DELEGATED HOUSEHOLDER DECISION

Item No. Report of the Head of Planning, Sport and Green Spaces**Address** 42 CAMDEN AVENUE HAYES**Development:** Single storey side/front extension (Retrospective application)**LBH Ref Nos:** 16103/APP/2014/854**Drawing Nos:** PARMAR-14-1
Photographs
Location Plan 1:1250**Date Plans Received:** 12/03/2014**Date(s) of Amendment(s):** 12/03/2014**Date Application Valid:** 26/03/2014**1. CONSIDERATIONS****1.1 Site and Locality**

PROPOSED SINGLE STOREY FRONT SIDE
EXTENSION (RETROSPECTIVE) AT
42 CAMDEN AVENUE - MAYBE MIDDX UB+OBW
SCALE: 1:100, 1:200
DATE: MARCH 2014
DRAWING NO: PARMAR-14-1

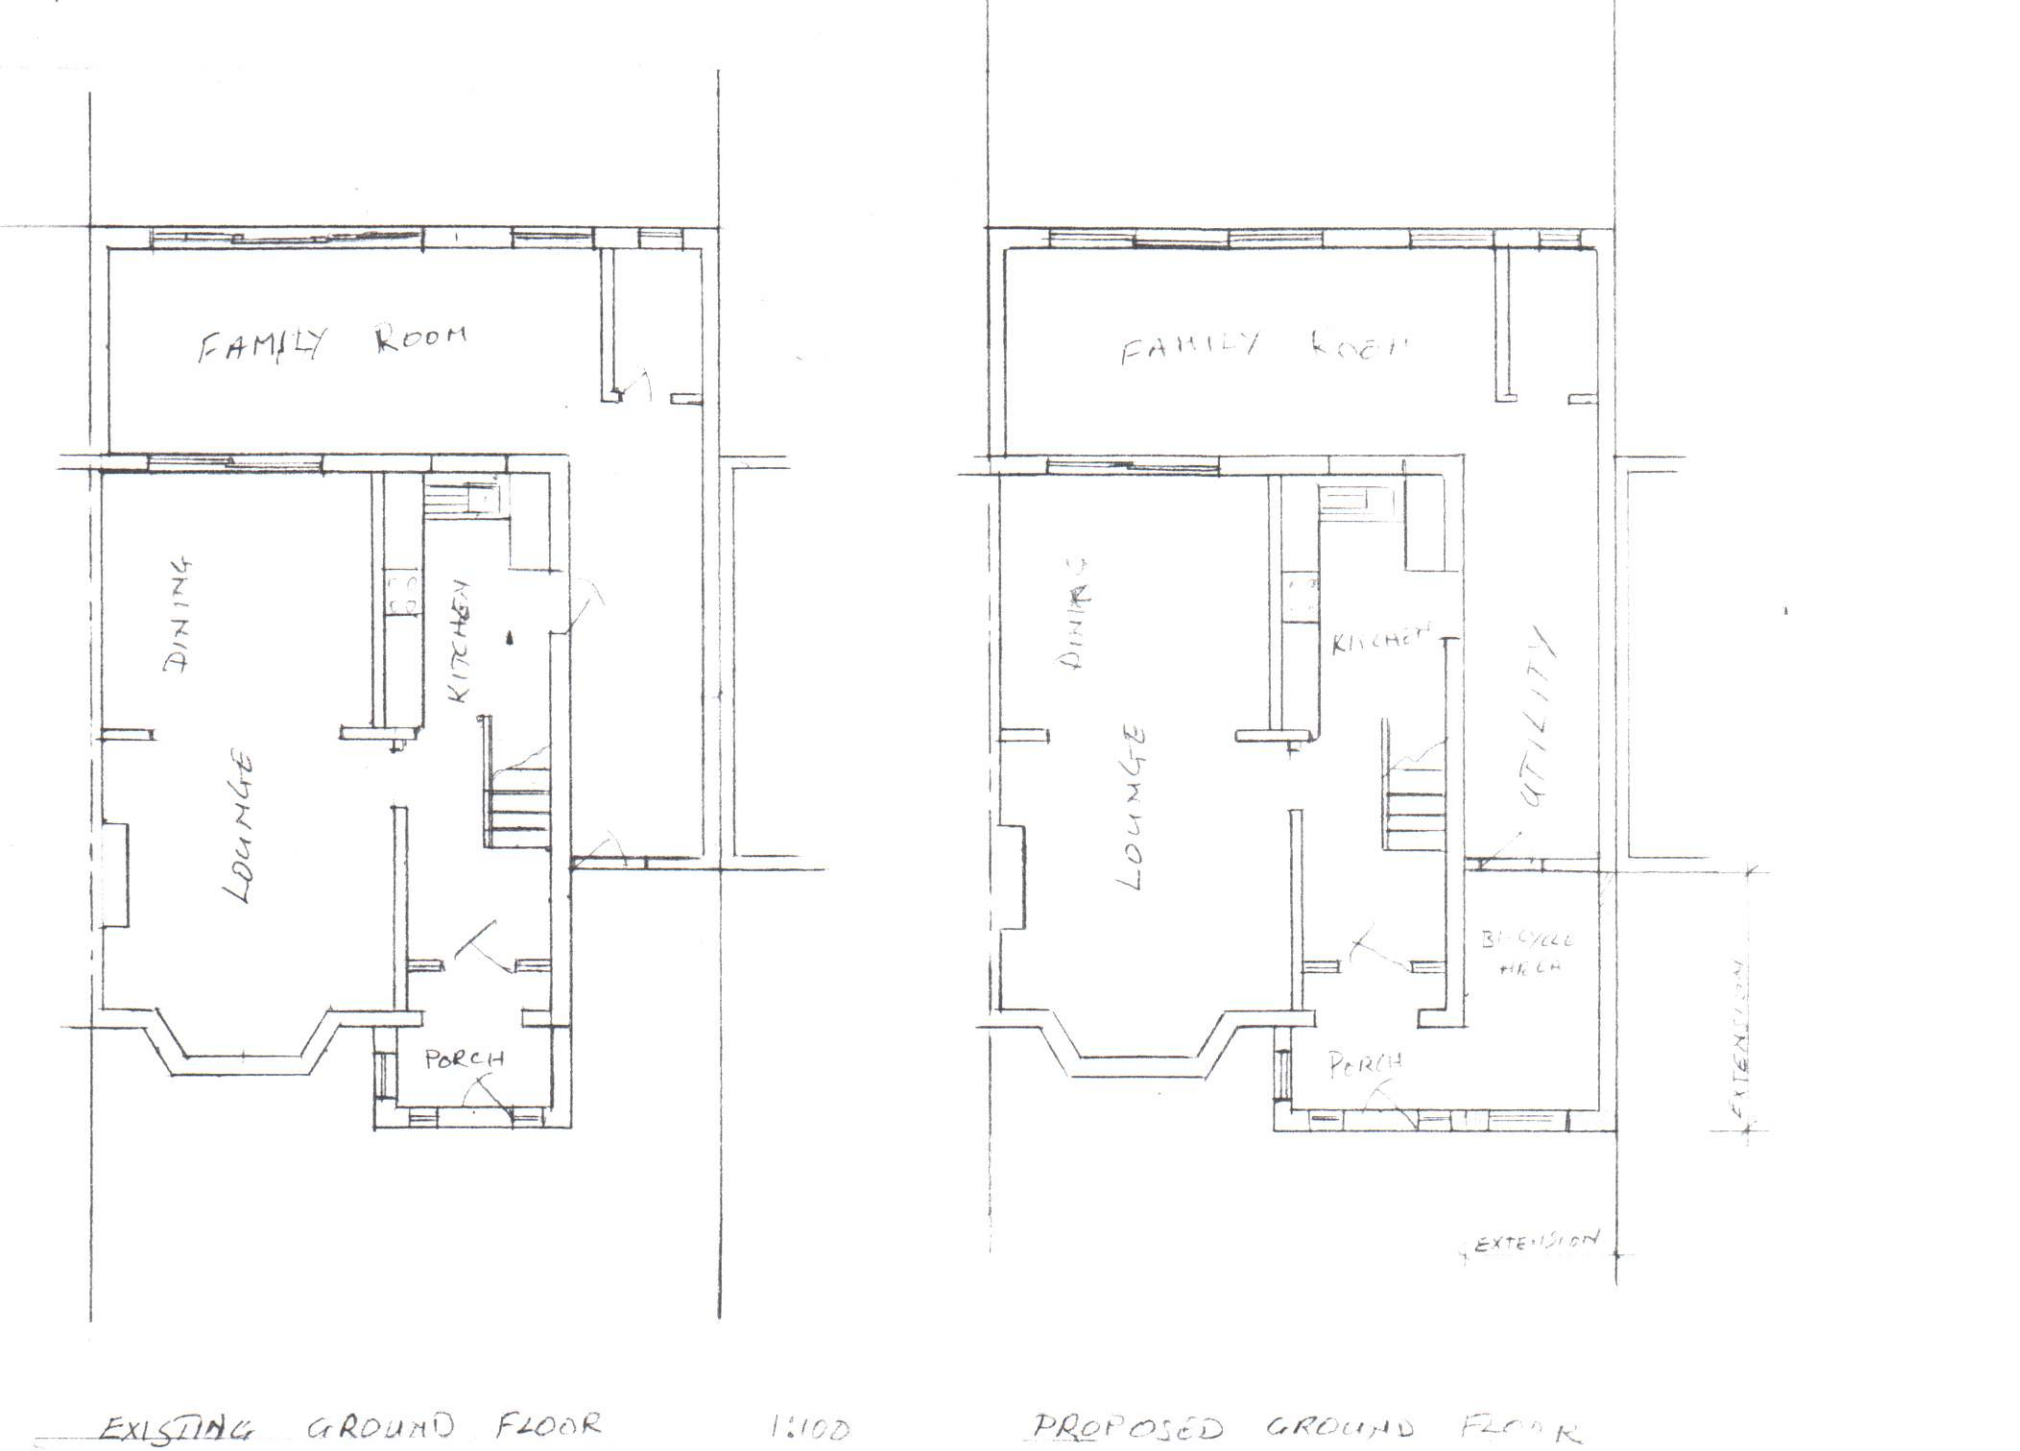
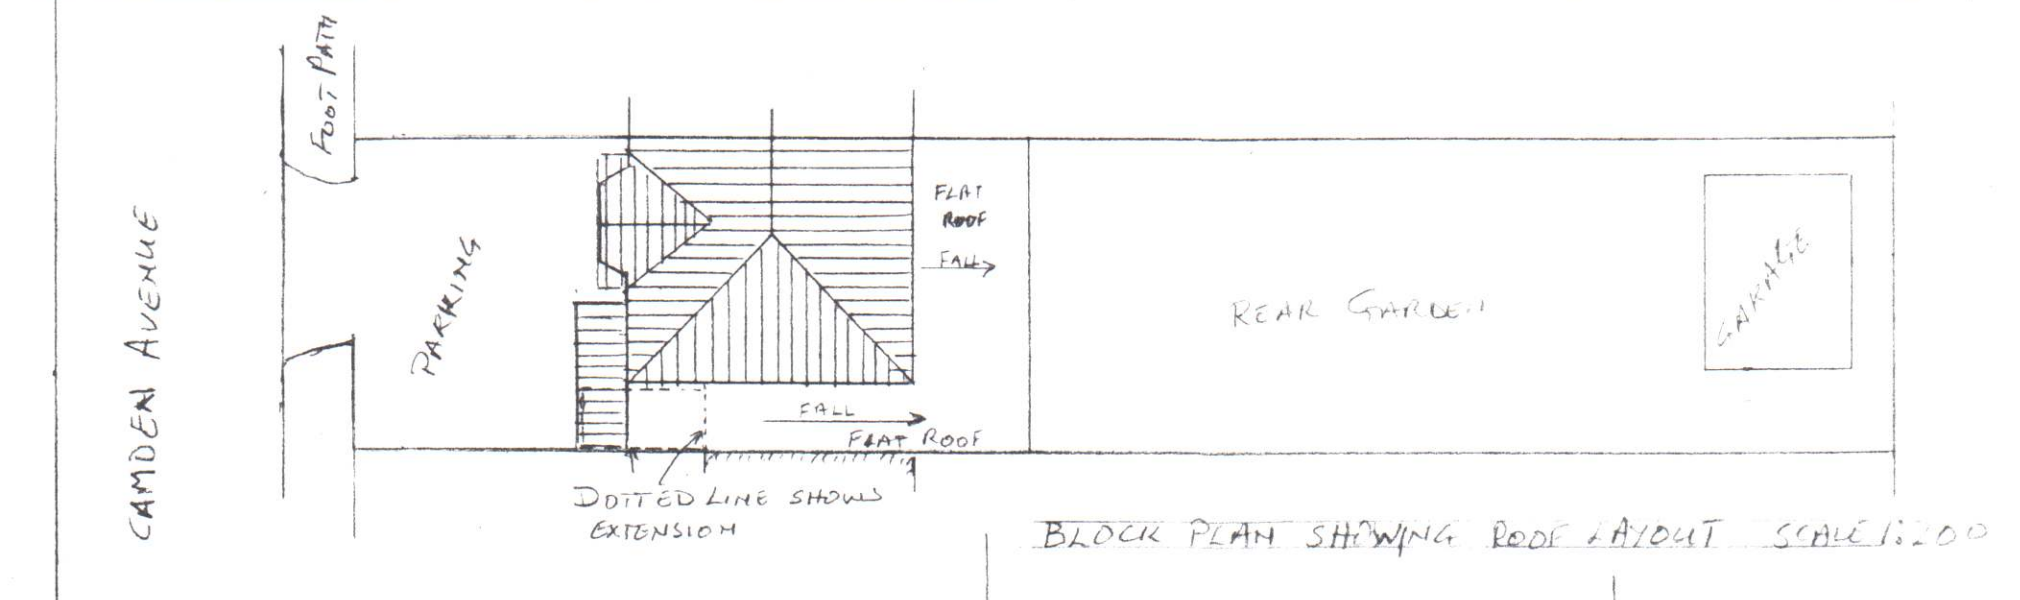
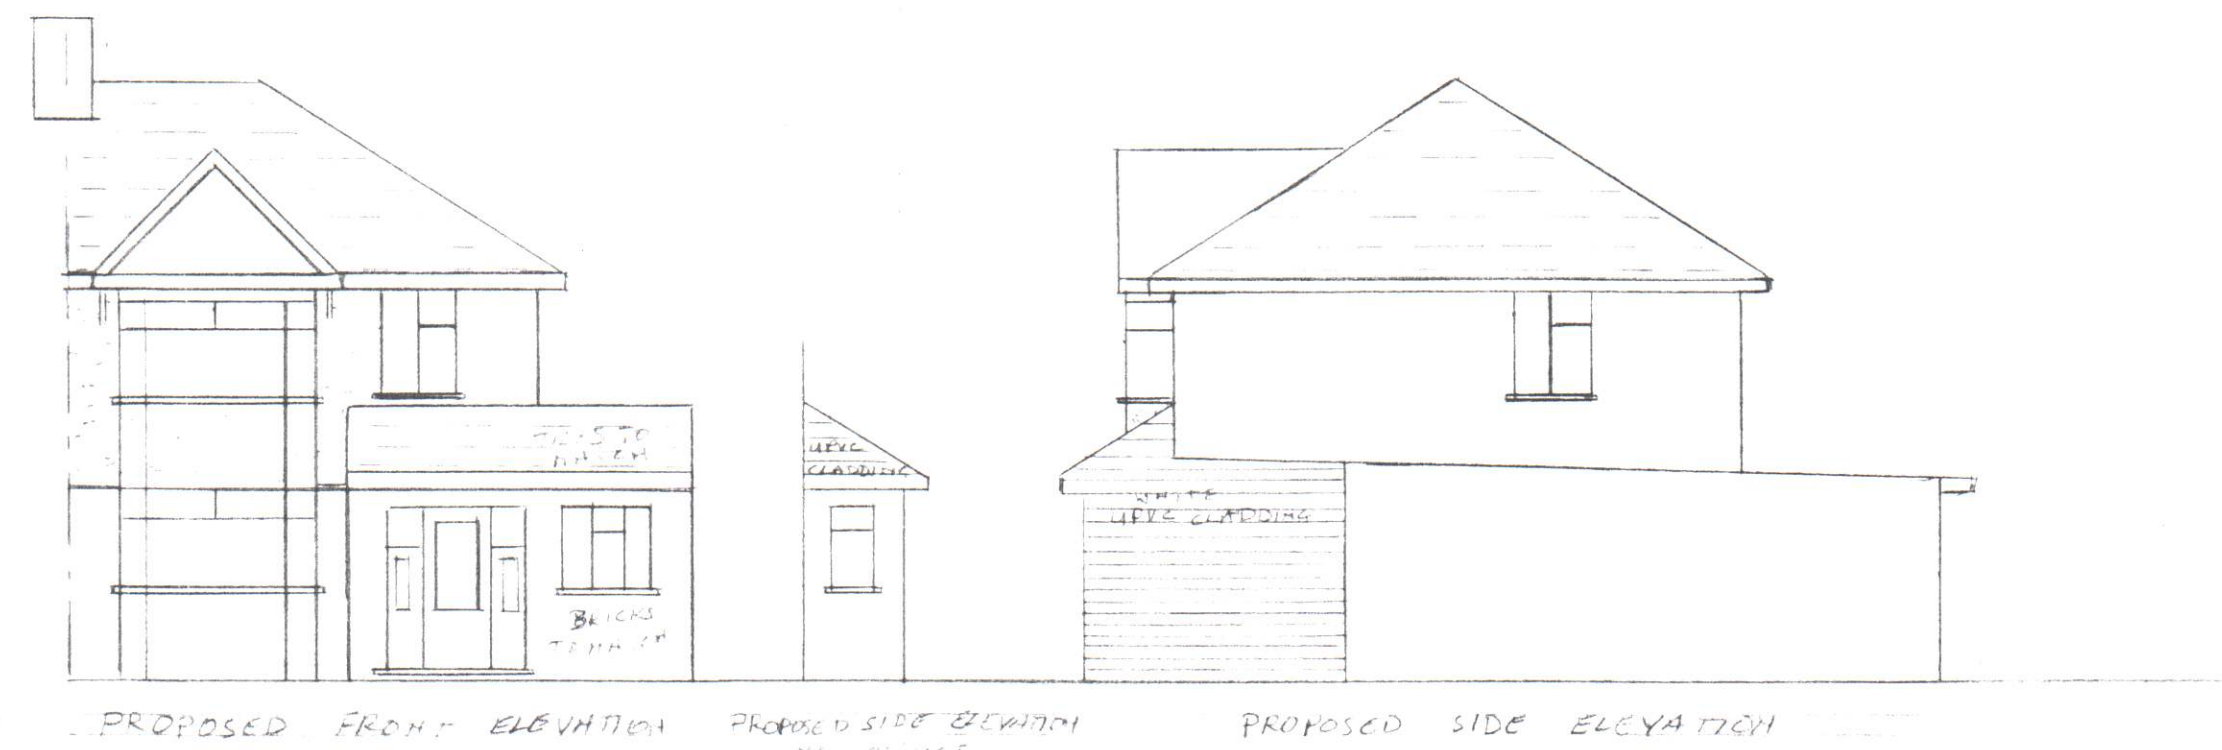
The application seeks retrospective planning permission for the single storey side/front extension. The extension has been erected to the front of the original garage and has a depth of 3.49, projecting approximately 0.75m beyond the front bay window. The extension has a width of 4.6m. The front extension has a dummy pitched roof measuring 3.65m in height reducing to 2.95m to the rear. Photographs have been submitted with the application to confirm that the original porch was damaged as a result of a car driving into it.

The proposal fails to comply with the advice set out in section 8 of the HDAS guidance. Having regard to the scale and bulk of the extension, and its forward projection beyond the bay window, the extension appears as an incongruous addition to this property which is out of keeping with the character and appearance with the street scene. This is further enhanced by the readily available views of the extension with it protruding forward of the adjacent terrace of properties. As such the proposal is considered to be in conflict with Policy BE1 of the Hillingdon Local plan Part One, Policies BE13, BE15 and BE19 of the Hillingdon Local plan - Part Two saved UDP Policies (November 2012) and the HDAS guidance Residential extensions.

The extension by reason of its excessive size, scale, bulk and forward projection, fails to appear as a subordinate addition to the property and appears as an incongruous form of development which fails to respect the architectural integrity of the host dwelling to the detriment of the visual amenity of the street scene and the character and appearance of the wider area. As such the proposal is contrary to Policy BE1 of the Hillingdon Local Plan: Part One - Strategic Policies (November 2012), Policies BE13, BE15 and BE19 of the Hillingdon Local Plan: Part Two - Saved UDP Policies (November 2012) and the adopted Supplementary Planning Document HDAS: Residential Extensions.
